DRB Application No.: 10DRB-70361

Project # 1001746

6. **Project# 1001746**  
10DRB-70361 MINOR - PRELIMINARY/  
FINAL PLAT APPROVAL

**Plat of
Tract 64-A-1
MRGCD Map 34**
 comprised of
 Tracts 64-A & 64-C, MRGCD Map 34
 City of Albuquerque
 Bernalillo County, New Mexico
 December 2010

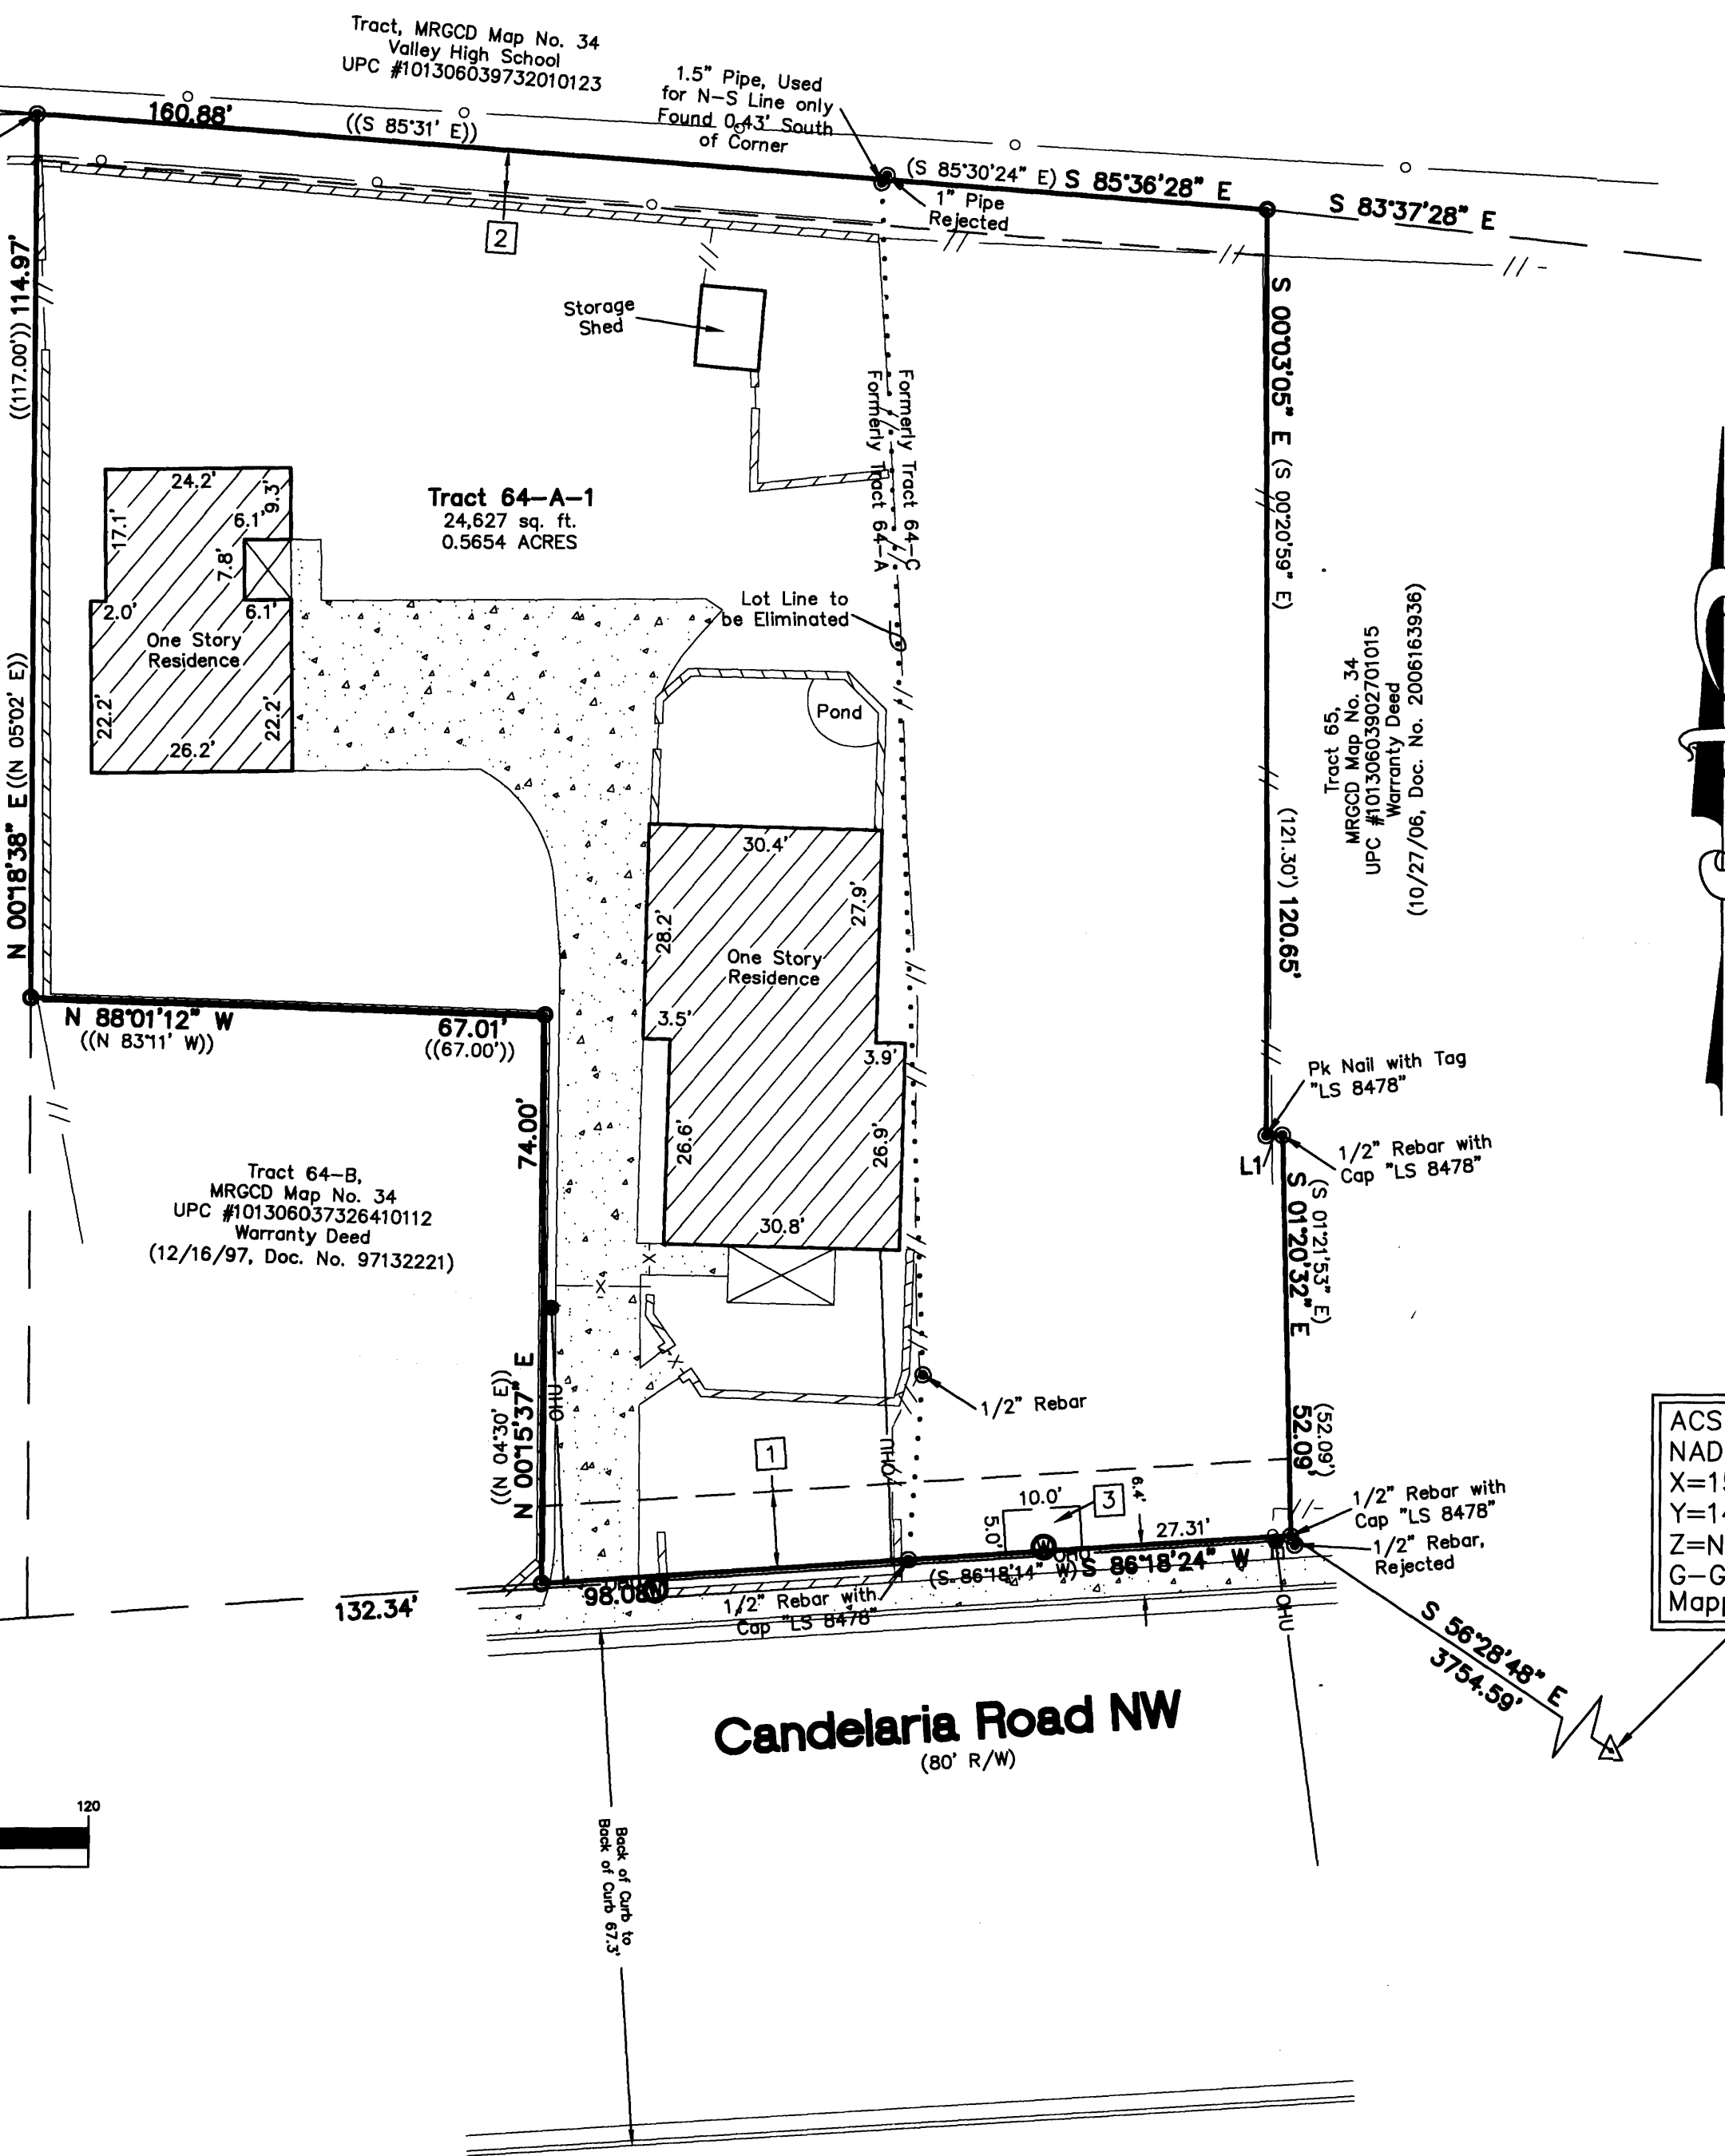
**TRANSPORTATION:** *OK verify wall modification for front yard*

CARTESIAN SURVEYS INC agent(s) for CARO  
RODRIQUEZ request(s) the above action(s) for all or a  
portion of Lot(s) , Block(s) , Tract(s) 64-A AND 64-C,  
**Unit(s)** , zoned RA-2, located on CANDELARIA RD NW  
BETWEEN SAN ISIDRO NW AND 12TH ST  
**THE PRELIMINARY/FINAL PLAT WAS APPROVED  
WITH FINAL SIGN OFF DELEGATED TO  
TRANSPORTATION TO VERIFY WALL MODIFICATION  
FOR FRONT YARD AND TO PLANNING FOR AGIS DXF.**
